PLANNING CONSULTATION RESPONSE

Application No	2026/0426
Proposal	Conversion of stable block to 1no. dwelling
Address	LOCATION: Land west of Cliff Lane, Brierley, Barnsley
Date of Consultation Reply	18/06/2026
Consultee	SYMAS

PROPOSED GARAGE PLAN
SCALE 1:50

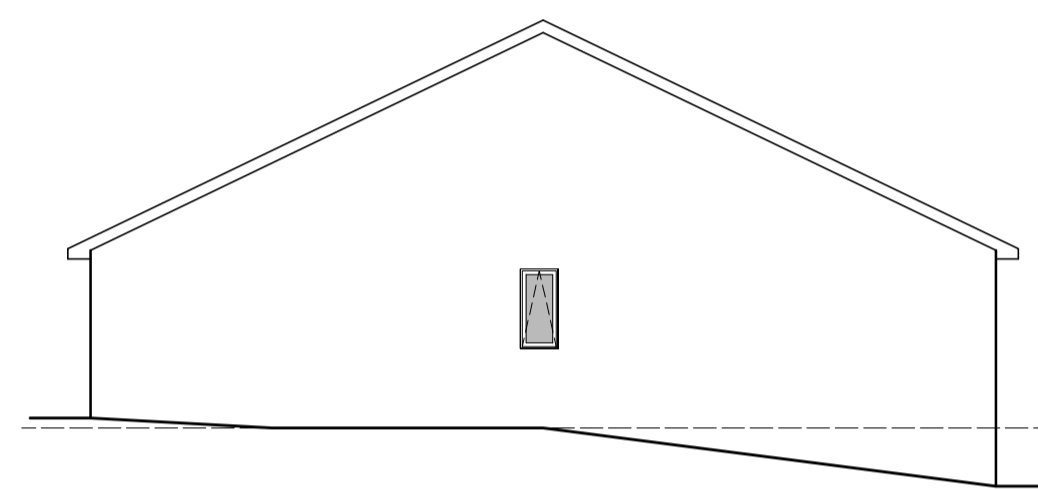
In consideration of the Mining Remediation Authority exemptions list, the stables conversion can be considered exempt from the coal mining risk assessment requirements. However a sizeable double garage is also proposed as part of the development for which SYMAS considers the evaluation of mining legacy health and safety/sustainability issues should be undertaken.

If planning permission is granted it is recommended that a condition be attached to the decision notice to ensure the recommendations of the CMRA are implemented prior to built development commencing.

The site has been identified to be at risk from potential coal mining legacy issues. Prior to commencement of built development, Intrusive site investigations must therefore be undertaken to evaluate the mining legacy risks and ground conditions as advised by the Geoinvestigate G22016, 31st Jan 2026. The site investigations and subsequent development should be undertaken in compliance with Construction Industry Research and Information association publication C758D "Abandoned mine workings manual" where applicable. A report detailing the findings of the investigation, and any recommended remediation/mitigation, shall be submitted for approval in writing to the Local Planning Authority. The development thereafter shall be carried out in accordance with the approved details. In the case of further stabilisation works being required, the condition will not be discharged until a validation report for the stabilisation works has also been submitted. Responsibility for securing a safe development rests with the developer and/or landowner.
